Comments for Planning Application 20/01575/FULL

Application Number: 20/01575/FULL

Address: 363 Ings Road Kingston Upon Hull HU7 4UY

Proposal: Erection of a single storey garage/outbuilding, built in the south-east corner of the application site (16.45m long x 9.75m wide x 4.49m high).

EAST & WEST ELEVATIONS AS PROPOSED SCALE: 1:50 @ A2 DECEMBER 2020 DRAWN: J W DRAWING NO:2465/P4/REV B

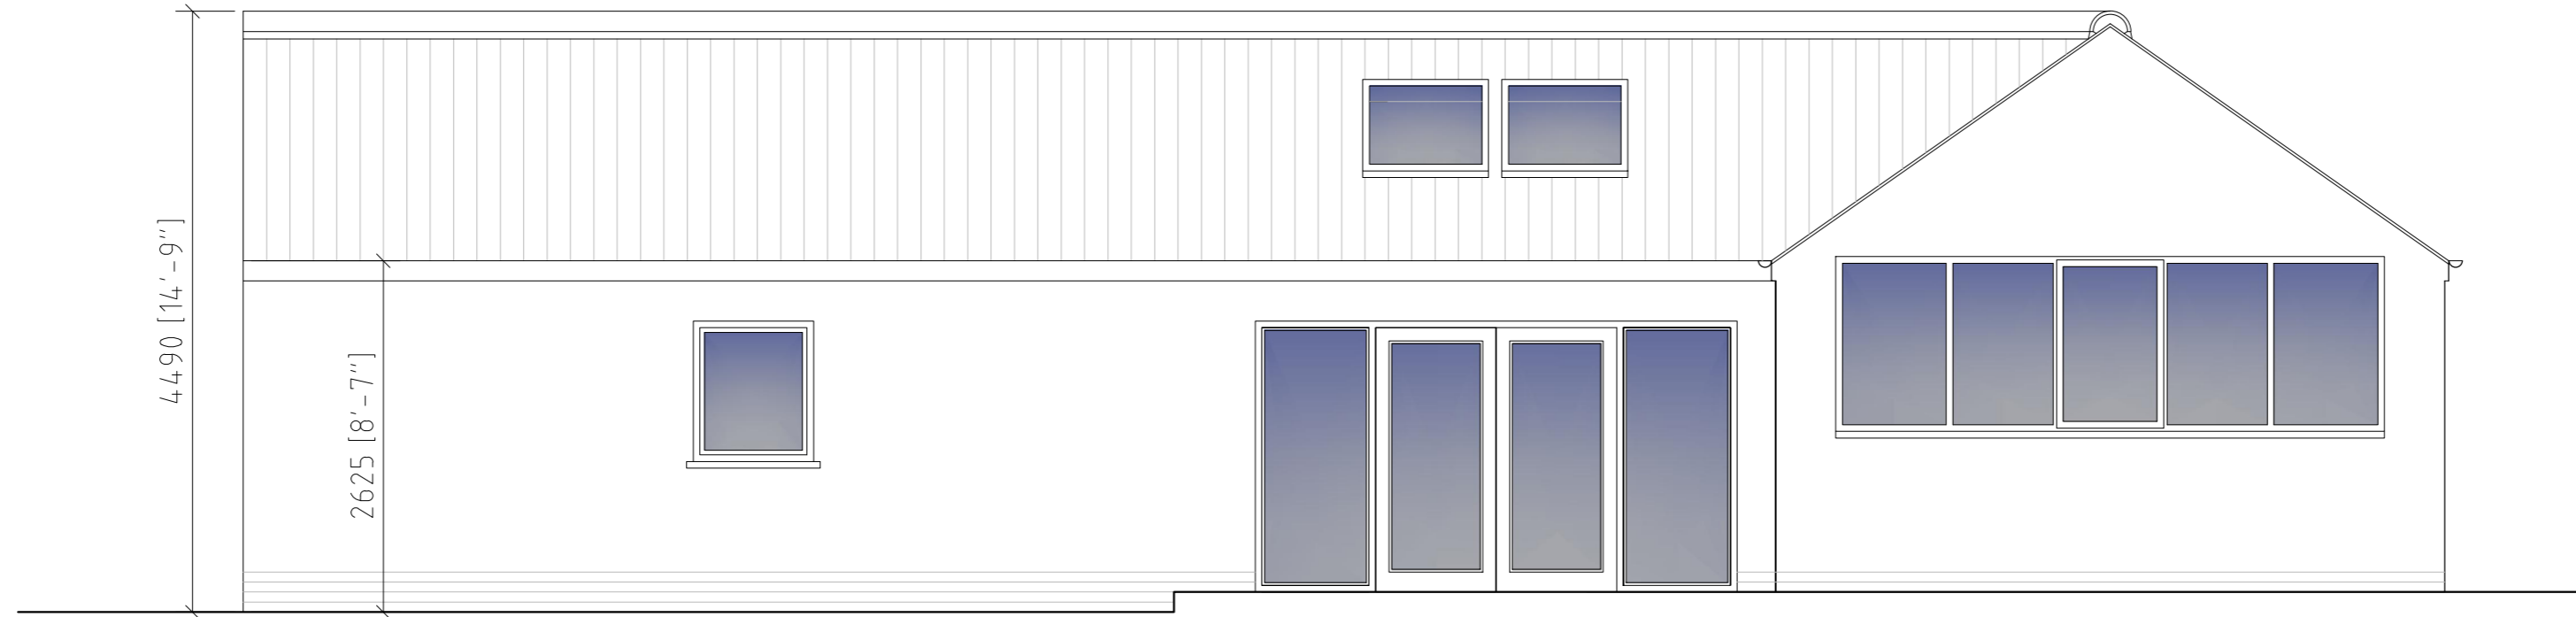
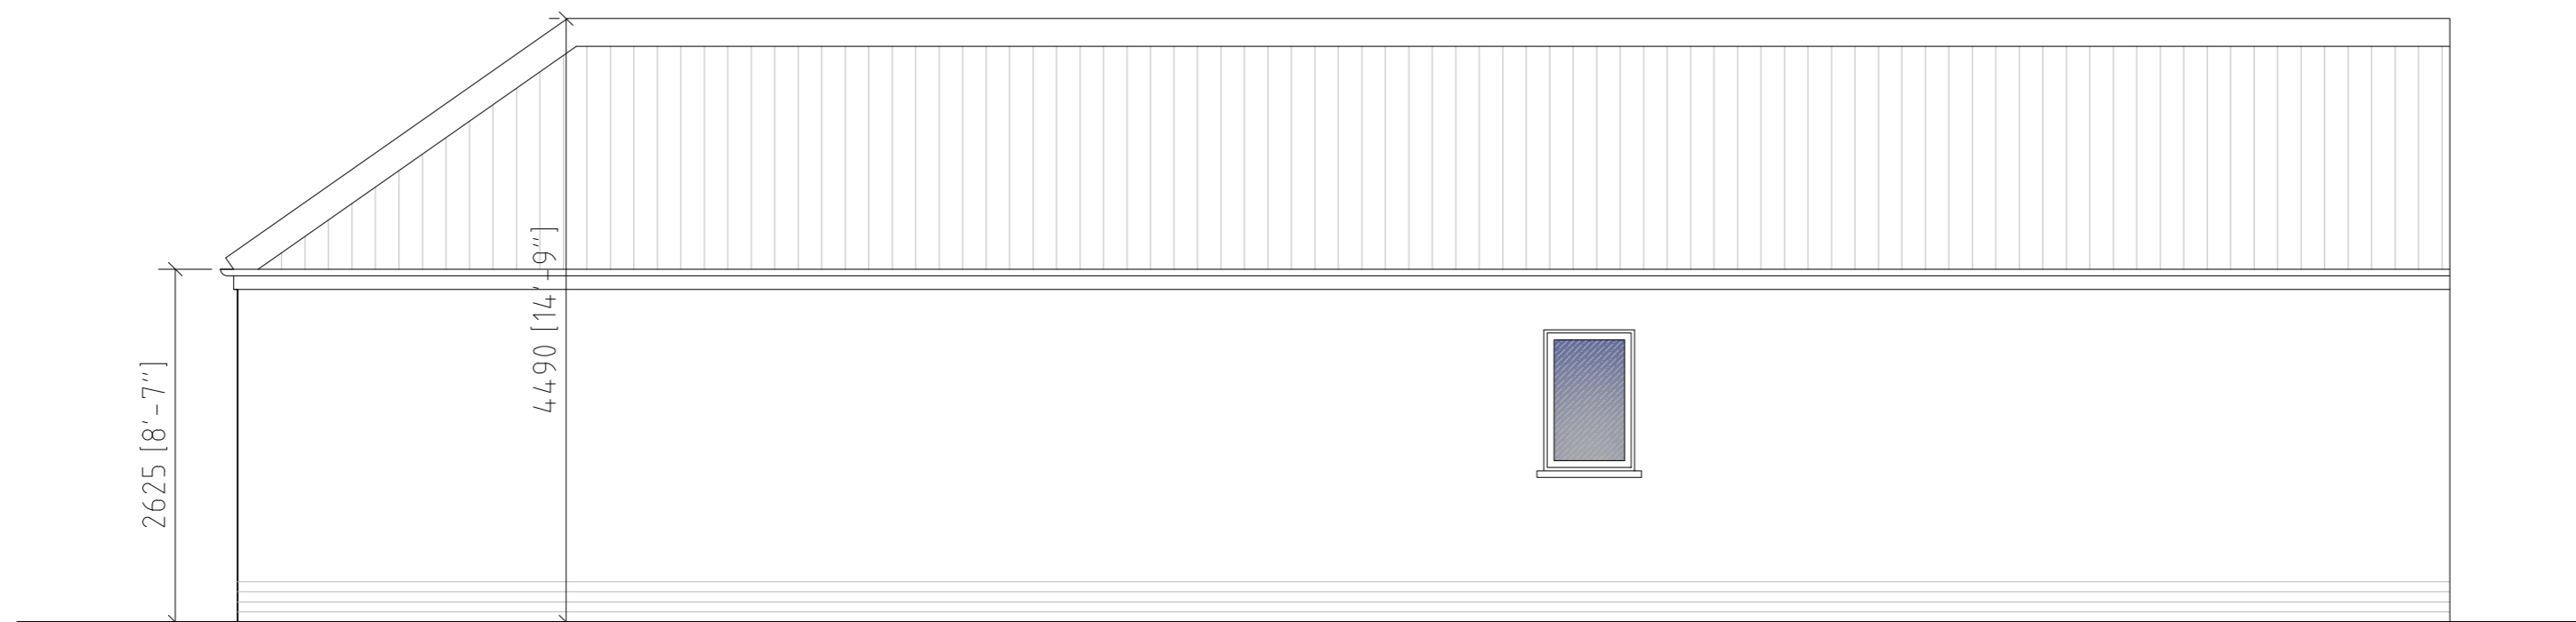
The dimensions are ludicrous in proposal to their specific needs for such a building and impinges on not only my rear garden but also that of our neighbours. For example, the height of 4.49m is incorrect because his land is already approximately 1m higher than my land therefore the total height that impinges on my land is 5.49m. This would cause further lack of light to the rear of my garden as long shadows would cut out the light especially later in the day. In my opinion the removal of the APEX roof, replaced by a flat roof maybe a compromise we would consider.

The length is also out of proportion (16.45m) covering almost 4 gardens and for us personally we would be left just staring at a wall and roof leaving us feeling hemmed in completely, making our own leisure time a misery.
